Planning Application No: 2026/62/91926/E

Address: 158 Hawthorne Way Shelley

Description: Change of use of garage to treatment room for hairdressing including installation of bi-fold doors to existing opening

PROPOSED MATERIALS	
• DOORS	— ALUMINIUM BI-FOLDS

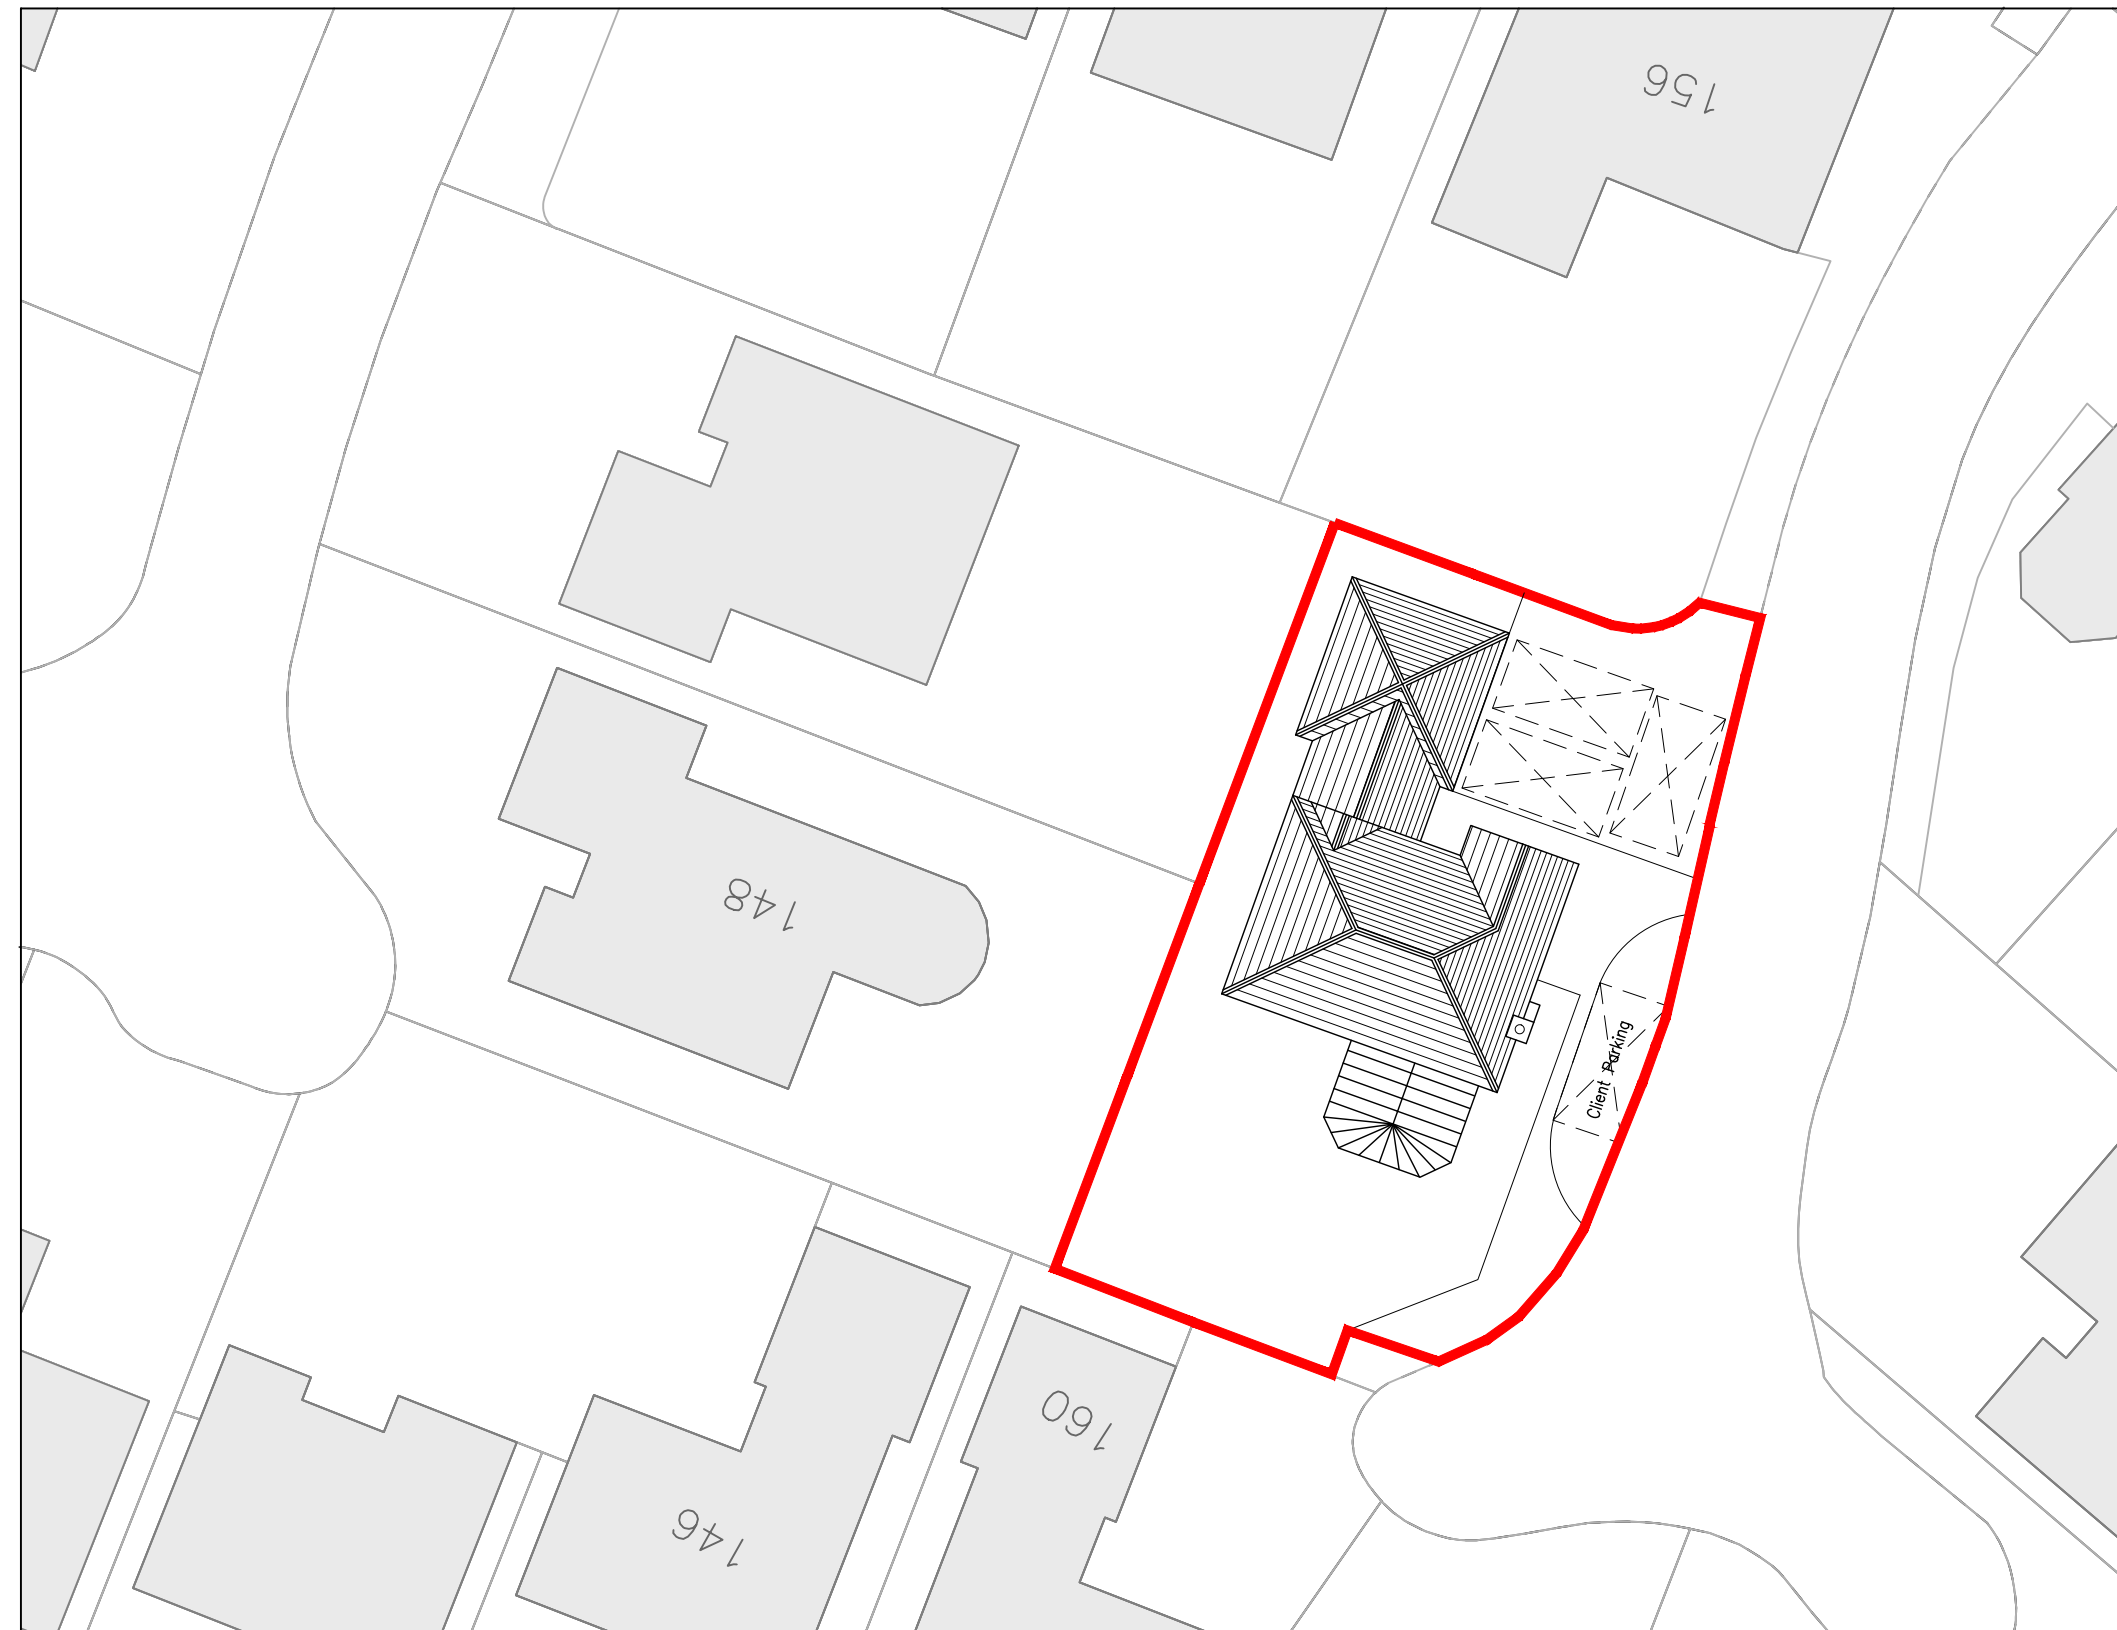
- The Planning Statement shows 3 parking spaces on the drive with two up to the property boundary. This doesn’t appear to take into account the ability to open the proposed bi-fold doors which are likely to require one metre of space to open. I’d question if there is space for 3 cars to be parked on the drive (excluding the service strip). Even though the width of the drive has recently been extended I don’t believe that the third car would be able to park across the bottom of the drive and would have to be across the service strip or protruding into the road. This makes it difficult for the neighbour opposite to reverse out of, or into their drive.

- As the drive has recently been extended (presumably without planning permission) does the applicant plan to make any changes to the area that has been marked as 'Client Parking' if it is deemed to be within their property boundary?
- Access to the business isn't clear but I presume it would be through the bi-fold doors; therefore, a clear gap would be required at all times between the bi-folds and the cars on the drive.

- b. The proposed space of 5.2m x 5.2 appears to be a particularly generous/spacious for one customer and the hairdresser at any one time. This would be double the space that was used at 46 Westerly Lane, and the size of the space lends itself to be used for multiple staff and customers.

- b. Some customers were observed to be at the property for up to 2.5 – 3 hours. With a single seat shown in the plans it's not clear where these clients will be whilst the applicant cuts the hair of the other clients seen to arrive at the property during the same time period. This suggests that there is a 'treatment room' separate from the hairdressing.
